Our ref: NO/2013/105329/01-L01
Your ref: 3/2013/0535
Date: 15 July 2013

**THE ERECTION OF A SINGLE COTTAGE (ALTERNATIVE SCHEME TO PLANNING PERMISSION 3/2011/0618)
LAND ADJACENT 10 THE DENE, HURST GREEN, CLITHEROE**

Ground Floor Plan 1:50

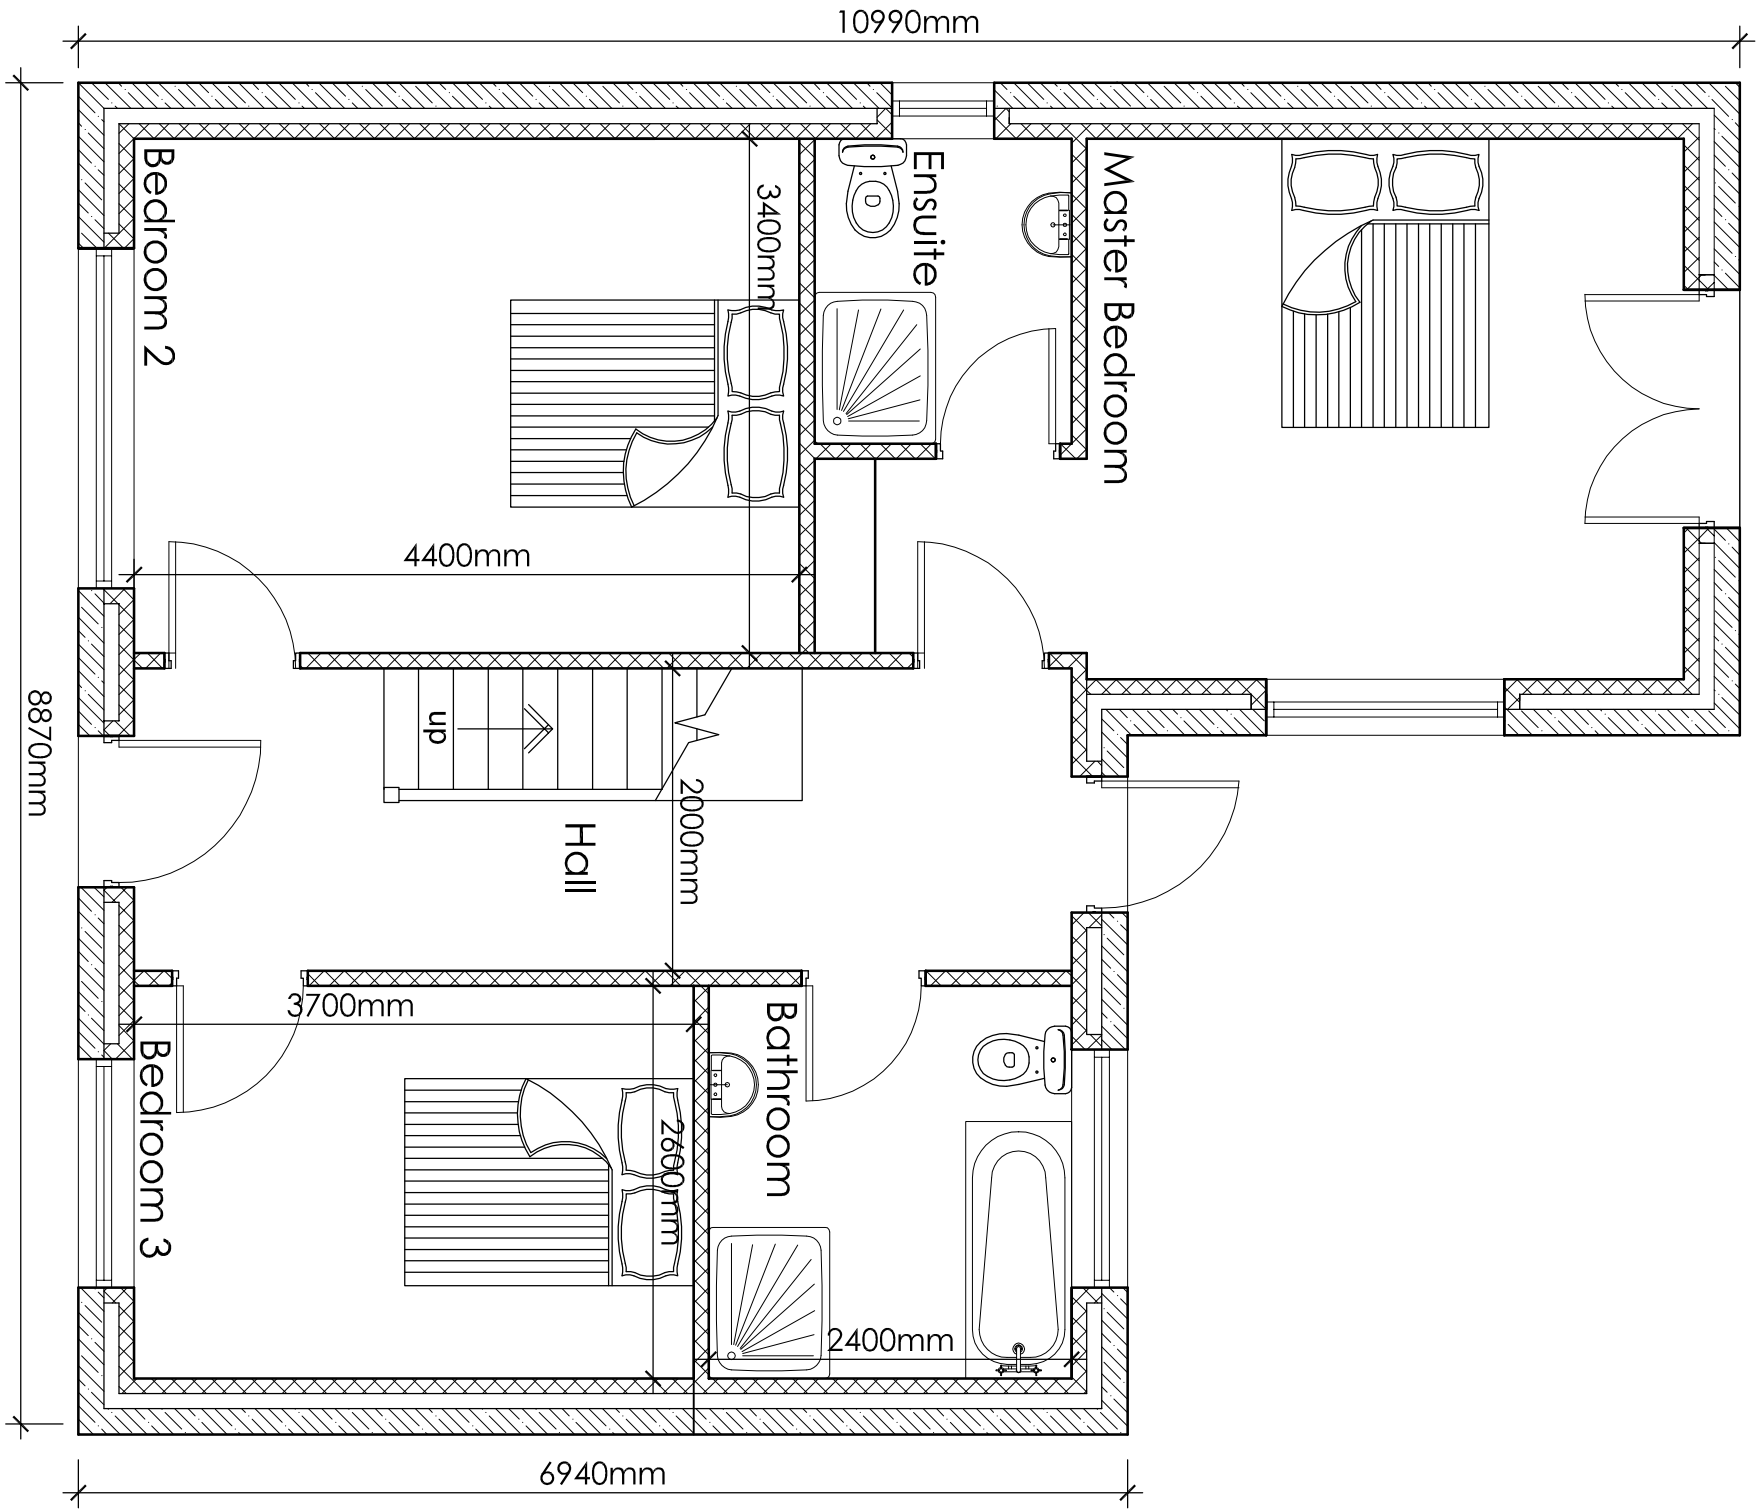
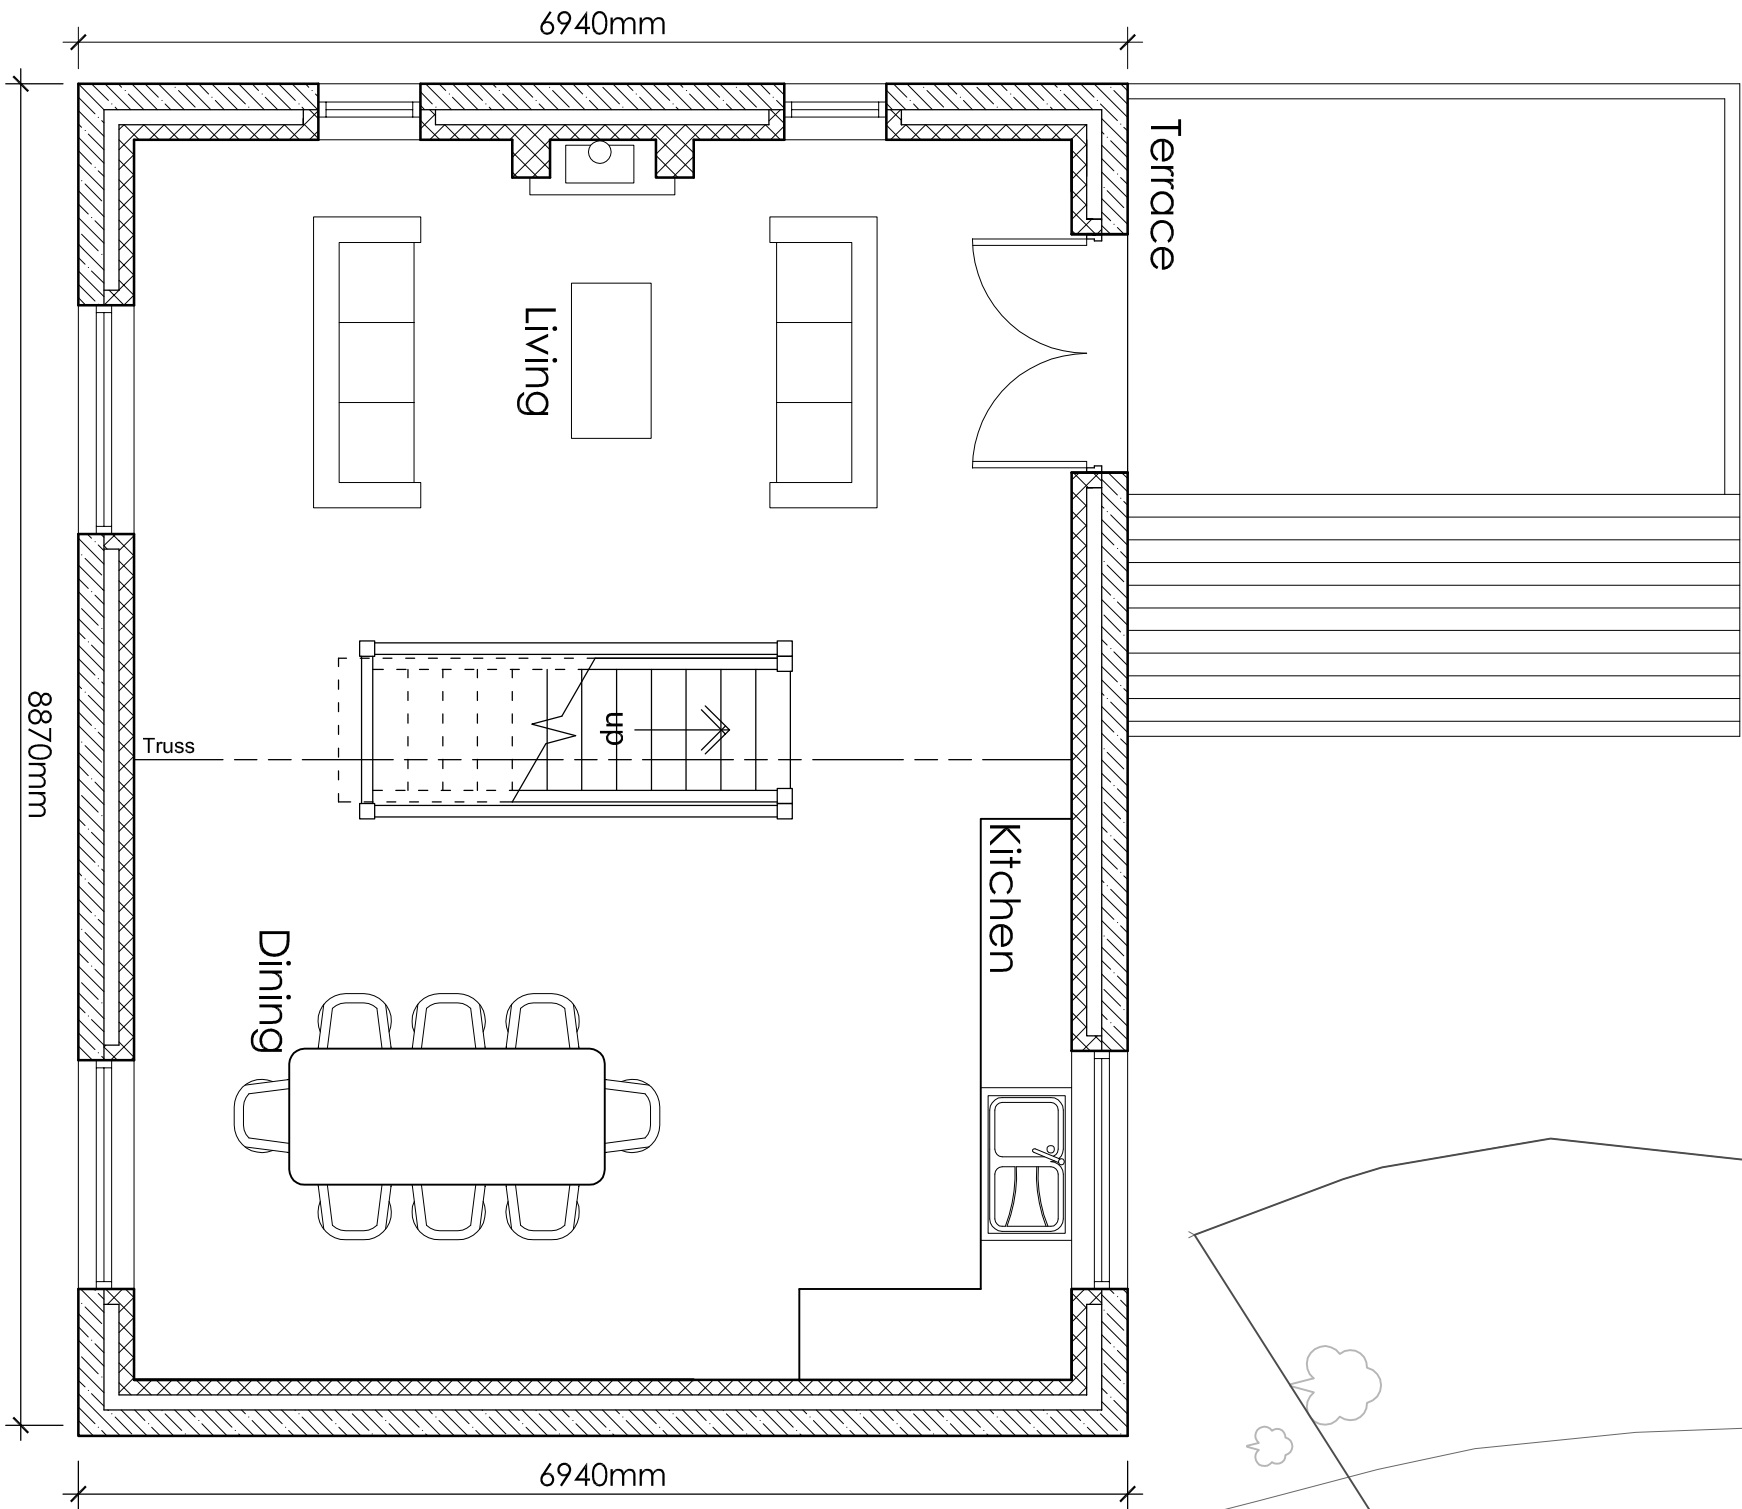
In particular, we are concerned that the alternative scheme as proposed seeks to locate bedrooms at ground floor level. The location of bedrooms at ground floor level could put future occupants at risk during the night when they are least prepared. The FRA submitted with the application is the same as that submitted with application 3/2011/0618 and makes no reference to the alternative layout and how the risk could be managed satisfactorily.

To overcome our objection, the proposed layout should be revised such that all bedrooms are located at the first floor to ensure that future occupants would not be at risk from any unexpected flood events overnight.
